Memorandum
Department of Planning and Urban Development
Planning Division

Date: Prepared on: June 8, 2012
 Prepared for: June 12, 2012 PB Workshop

Re: **Fore India Middle, LLC, Opechee Construction Corporation**
203 Fore Street (part of the redevelopment of 207-209 Fore Street)

1 FORE STREET BUILDING ELEVATION
 A6 1/16" = 1'-0"

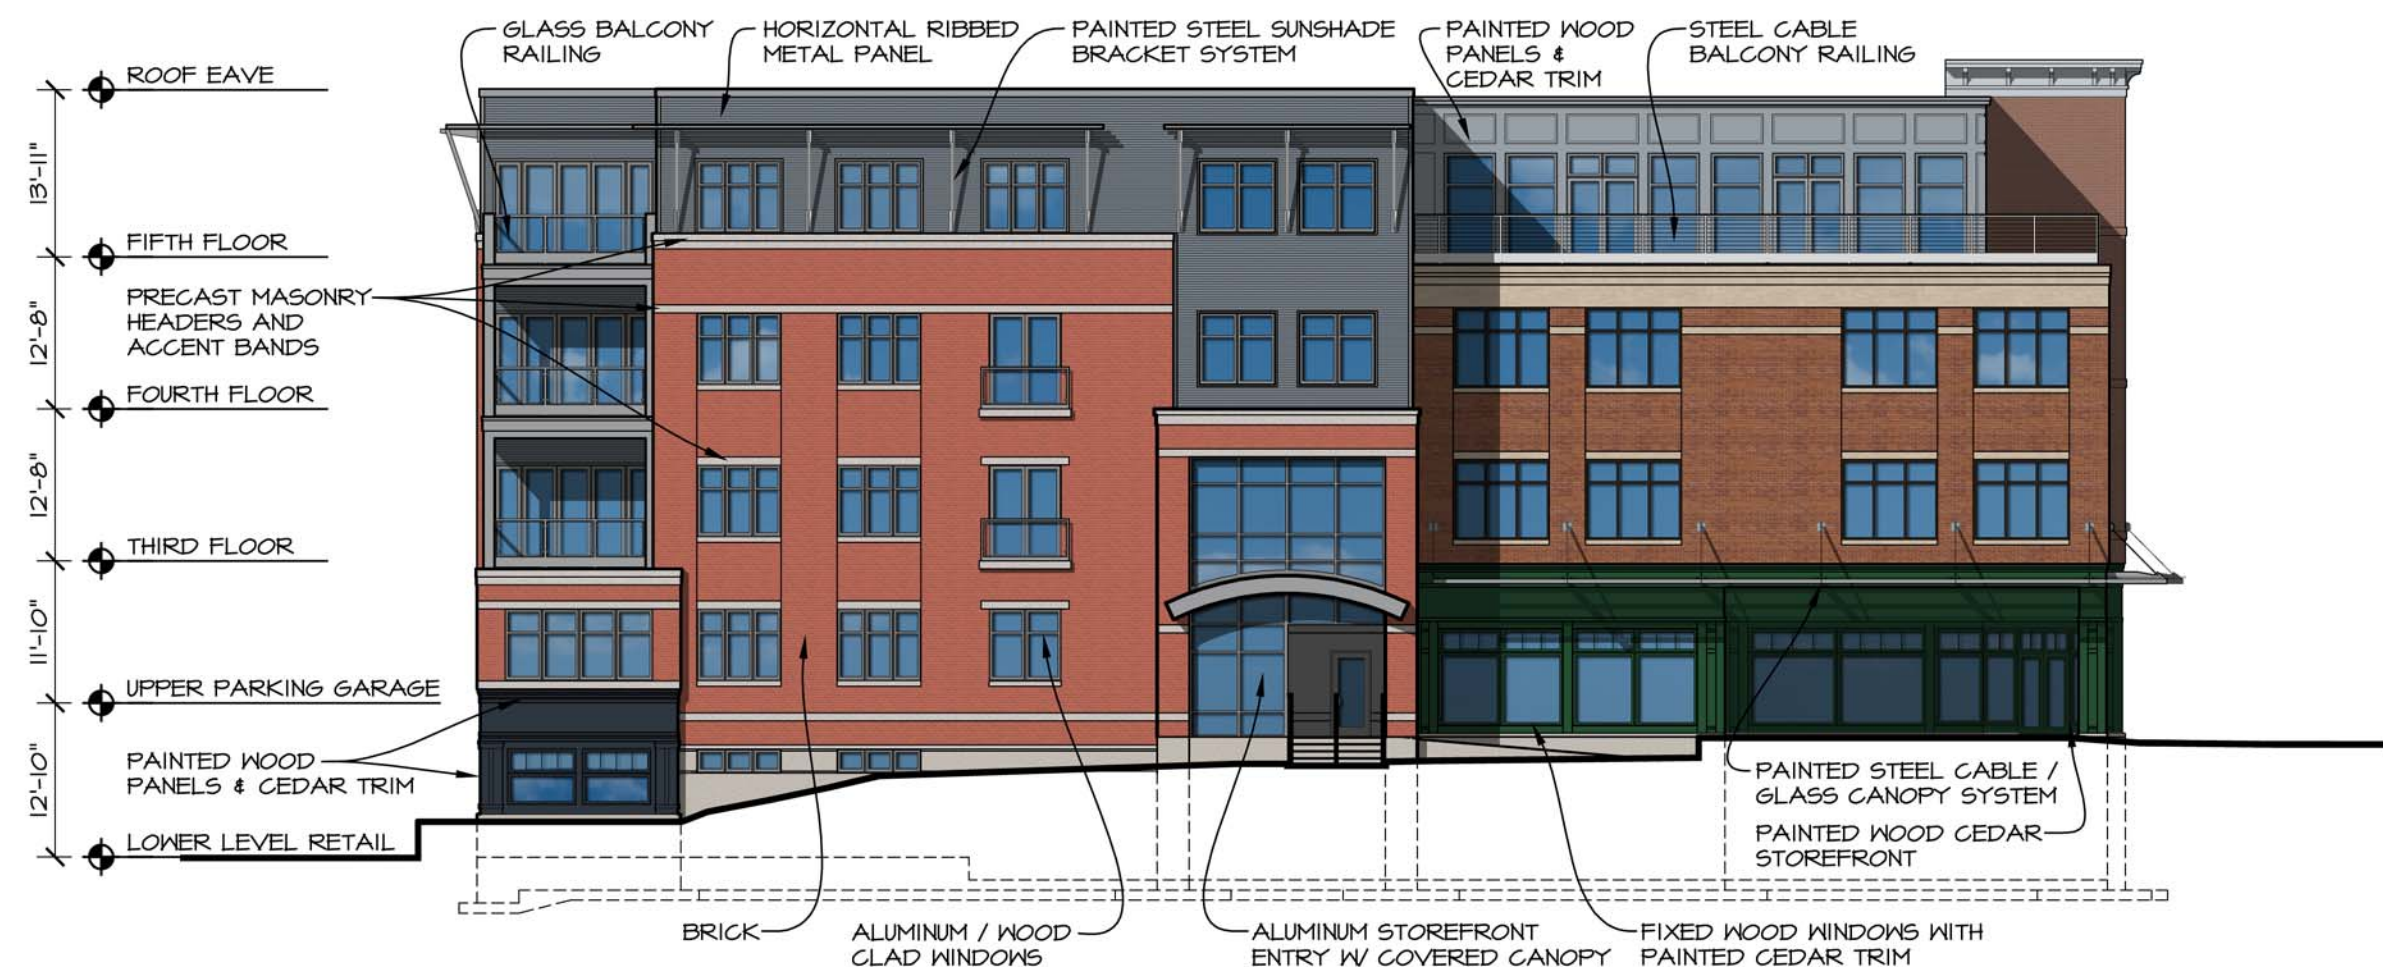
- The proposed building is set back some 35 feet from Fore Street near the corner with India Street (see photo right). The Landscaping Plan ([Attachment J.8](#)) and rendering ([Attachment J.20](#)) shows this as a sunken area reached by steps and hidden by shrubs- creating an area that may not be visible from the public areas around it. Staff have suggested in the Design Review Memo ([Attachment 7](#)) that this area may be more successful if designed as an attractive and more open mini-plaza with seating. The City Arborist has also suggested curbed planters could be incorporated ([Attachment 6](#)).

Materials: the elevations refer to brick veneer and staff have reservations regarding this material; samples of this and other materials and glass (where tinted) are requested;

FORE STREET LOWER LEVEL FLOOR PLAN
SCALE: 3/64" = 1'-0"

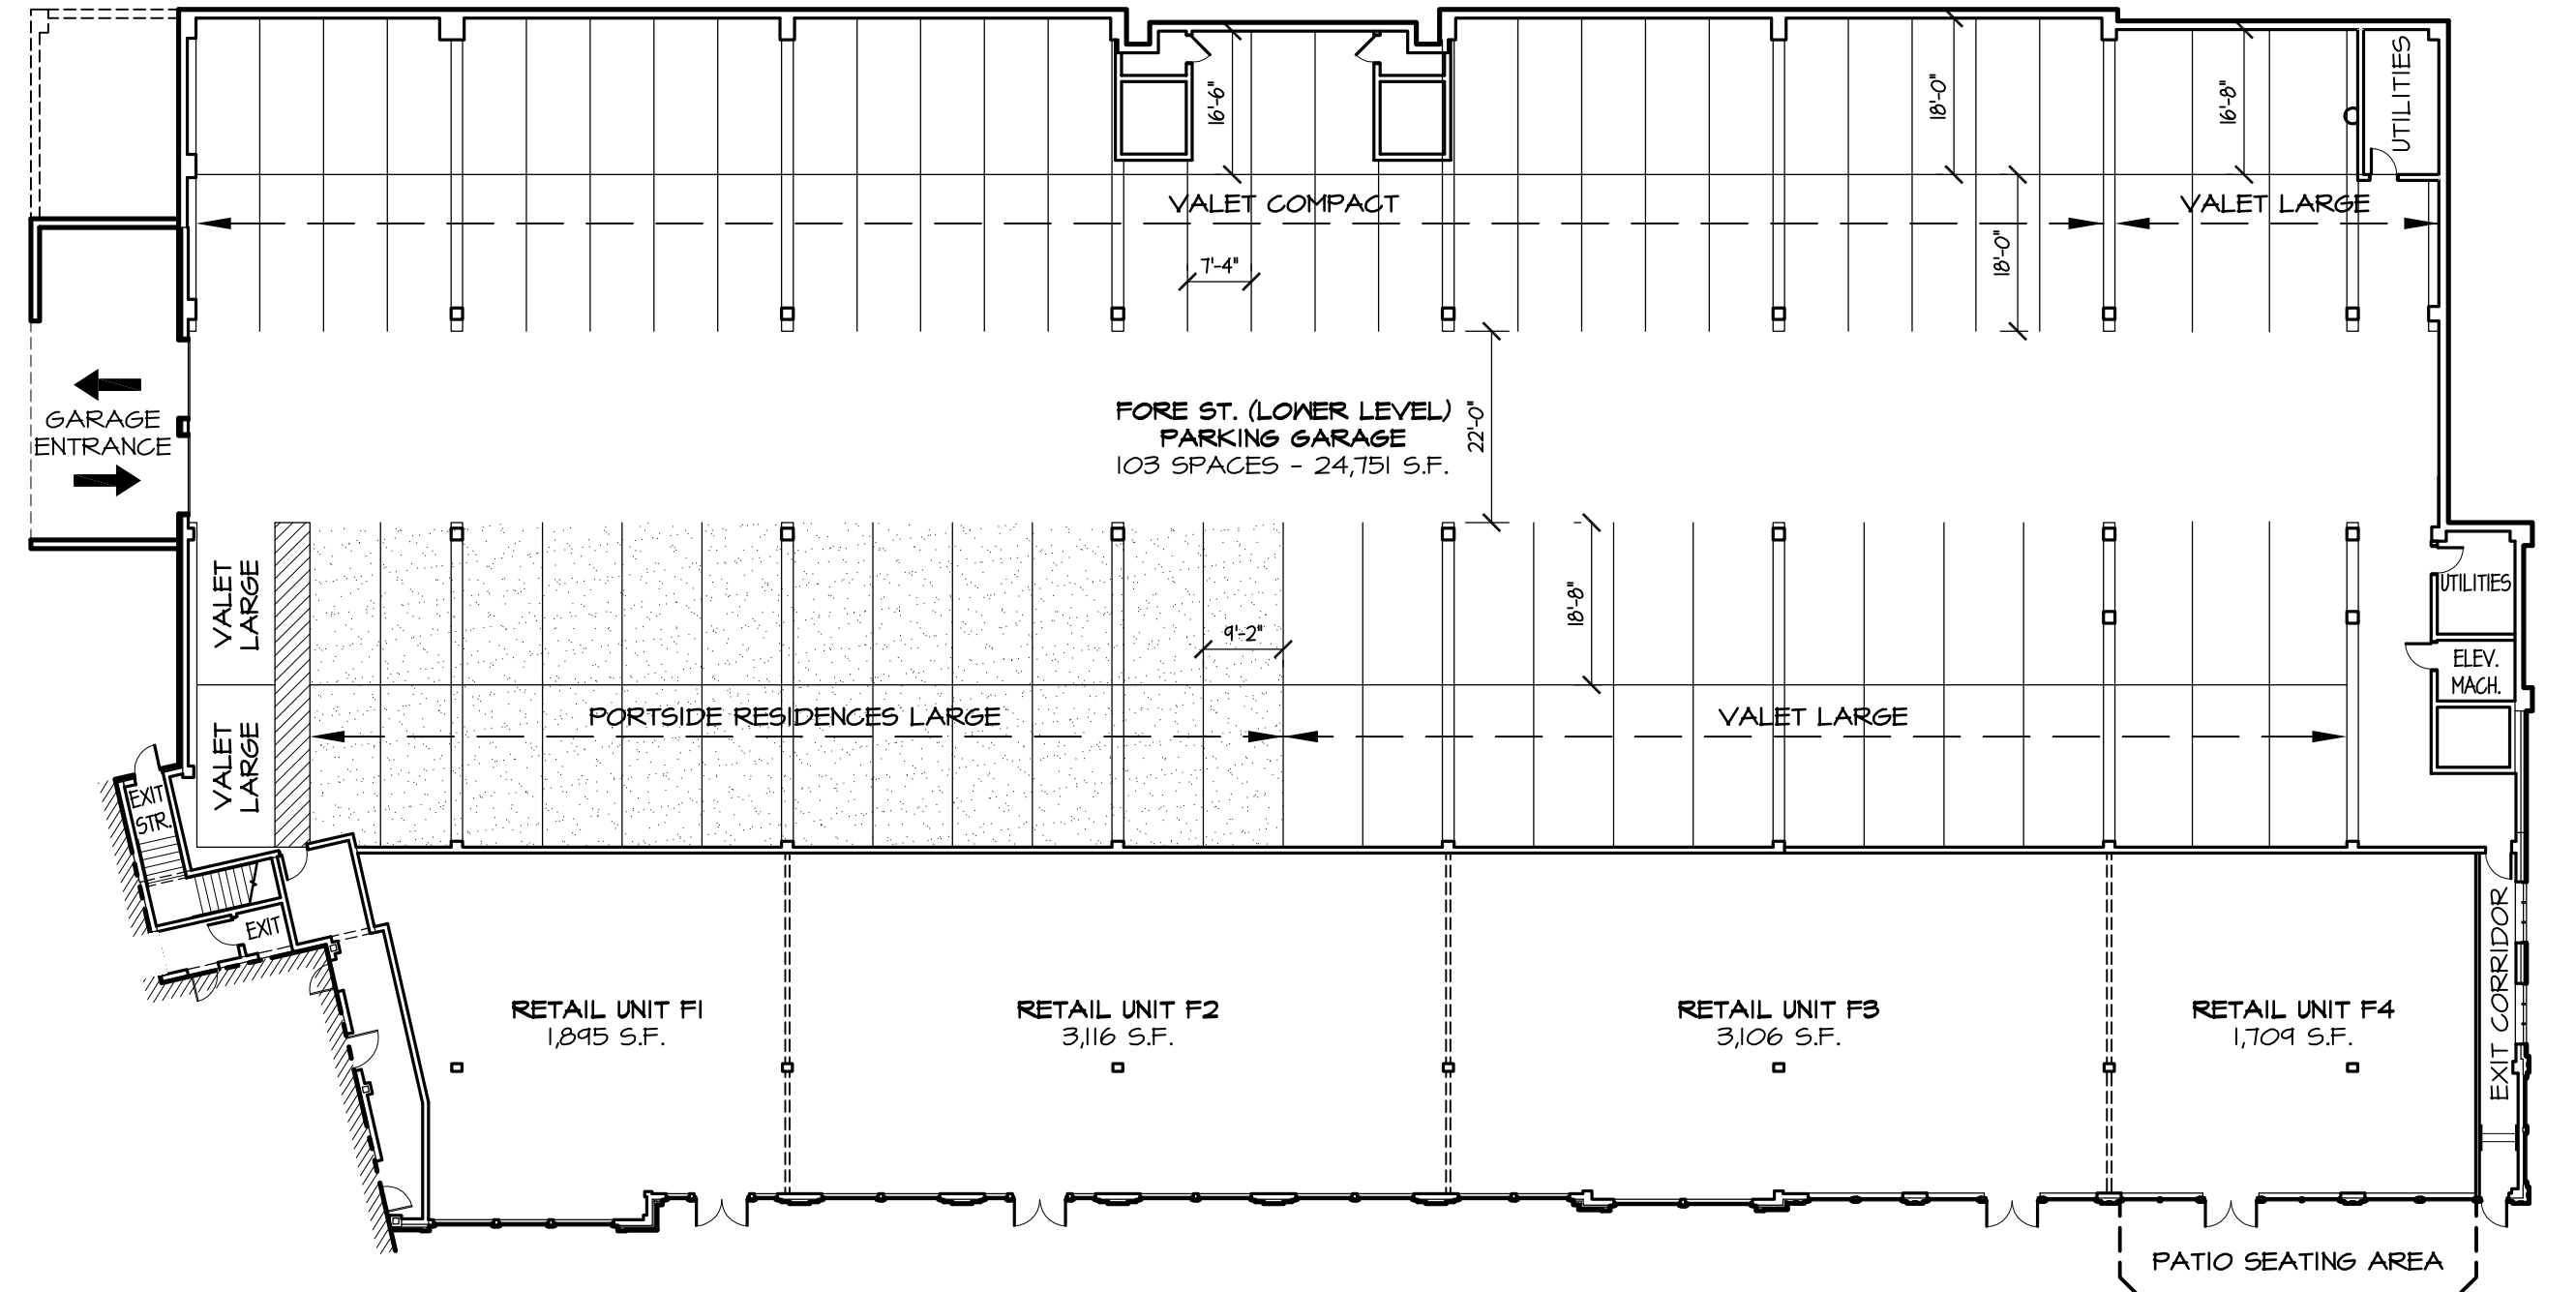
The Middle Street driveway access into the parking garage is proposed to be 42 feet wide, which includes a 24 foot wide access to the parking garage, a 15 foot wide loading bay and a 3 foot support column between these two. The proposed width exceeds the technical standard of 36 feet and the applicant has submitted a waiver request (Attachment B) for the wider curb cut. Although the radii are designed to minimize the length of the curb cut that pedestrians must cross, staff remain concerned about pedestrian safety as confirmed by Tom Errico's comments (Attachment 2):

The driveway width exceeds City standards and accordingly will need a waiver from the City's Technical standards. I support a waiver, but would like the applicant to provide recommendations on how best to design the driveway for optimal pedestrian safety.
